## Householder Application for Planning Permission for works or extension to a dwelling

16 balder rd

<p><b>Type:</b> Other</p> <p><b>Other (please specify):</b> heat pump</p> <p><b>Existing materials and finishes:</b></p> <p><b>Proposed materials and finishes:</b> Daikin Altherma 3M heatpump</p>
---

- **Noise disturbance from New Plant**

16 balder rd property and heat pump

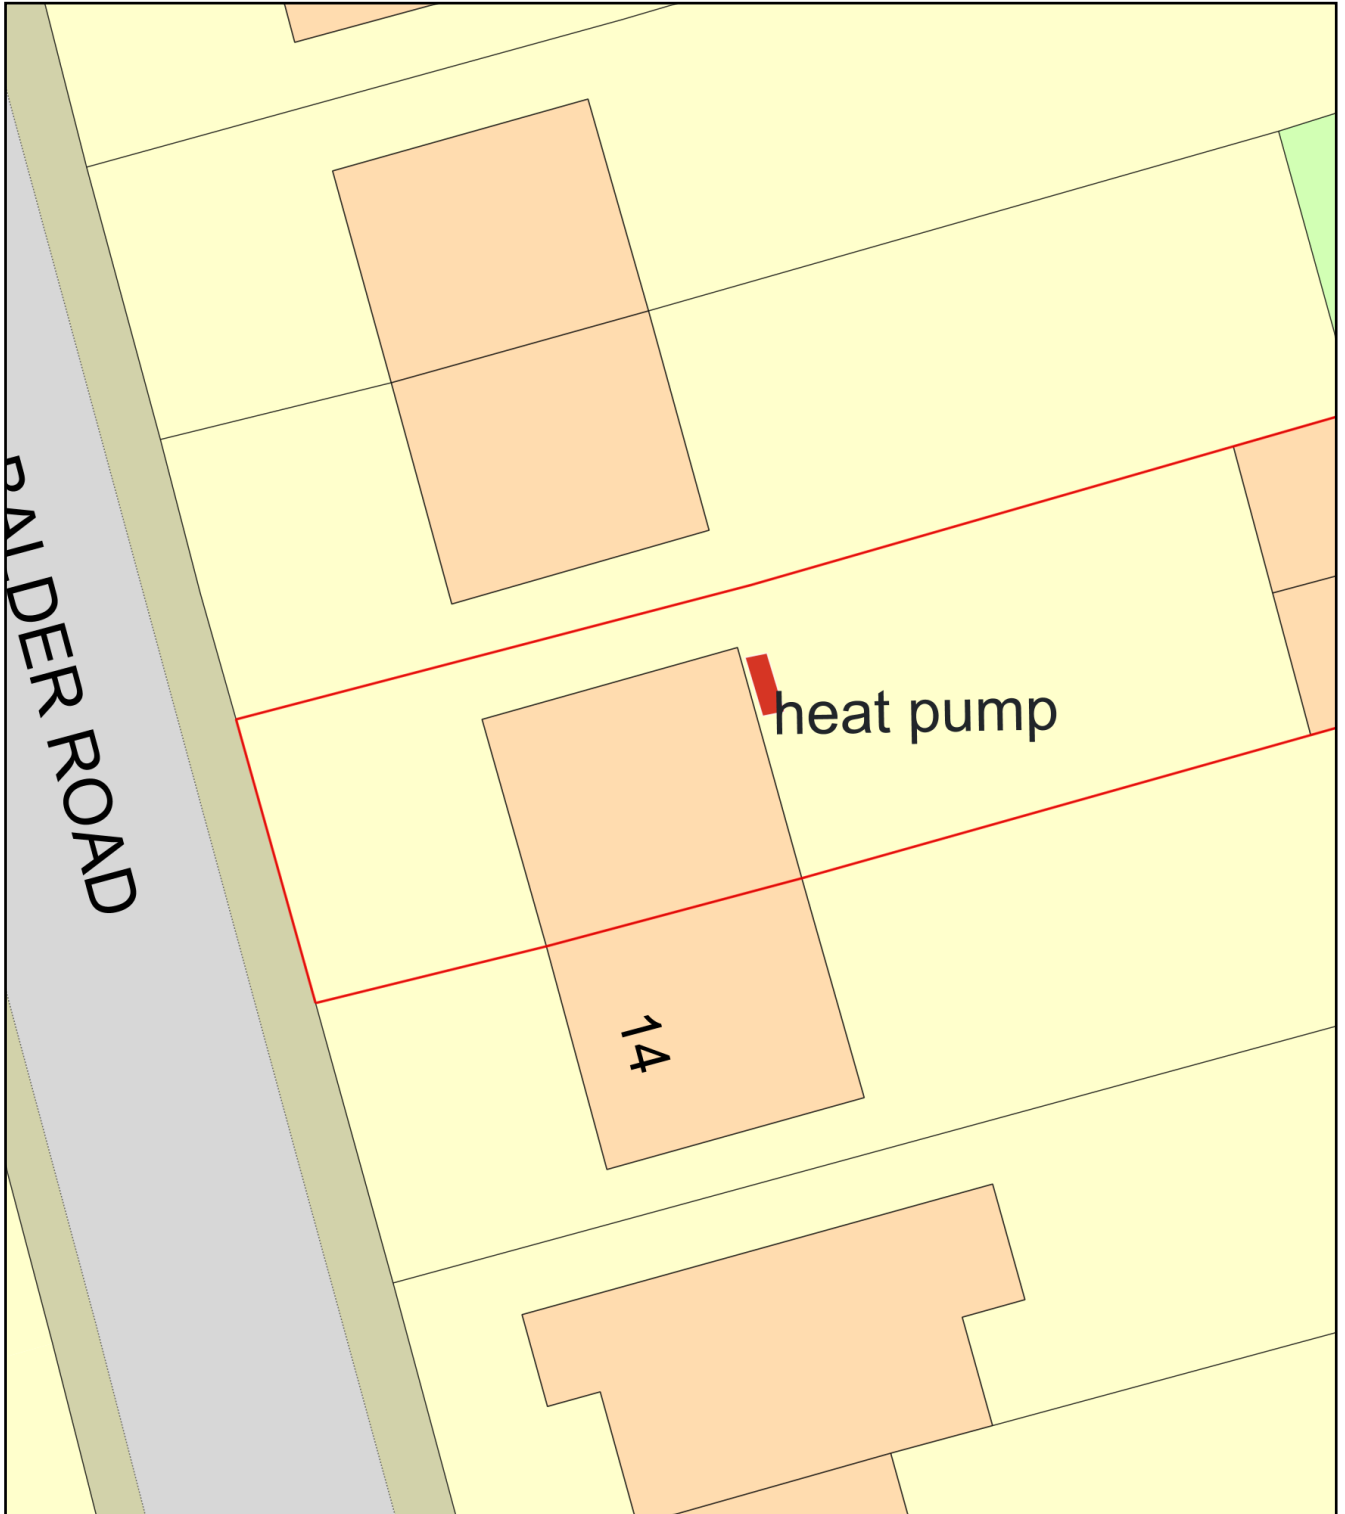
Please forgive the delay in my response, I have taken a look at the information you have provided and I find the situation borderline as given the location, directional noise and the ability to use the unit free over a 24hr period the noise level of the 8Kw unit may cause issues to future neighbouring properties.

I would recommend you request the company fitting the equipment to see what options there are for a noise assessment of the background noise level at you property before they install the unit and whether they have any mitigation options should the noise assessment prove you may require them.

They may say they have fitted hundreds but every location is individual and as you need to use this location and you have no option to move it further away from the boundary then they need to help you with this assessment. They need to assess the background level over a 24 hour period and ensure that the unit doesn't exceed that level during the night. This is the condition that will need to be addressed.

The rating level of sound emitted from any fixed plant and/or machinery associated with the development shall not exceed background sound levels by more than 5dB between the hours of 0700-2300 (taken as a 1-hour LA90 at the nearest sound sensitive premises) and shall not exceed the background sound level between 2300-0700 (taken as a 15 minute LA90 at the nearest sound sensitive premises). Where access to the nearest sound sensitive property is not possible, measurements shall be undertaken at an appropriate location and corrected to establish the noise levels at the nearest sound sensitive property.

Any deviations from the LA90 time interval stipulated above shall be agreed in writing with the Local Planning Authority.
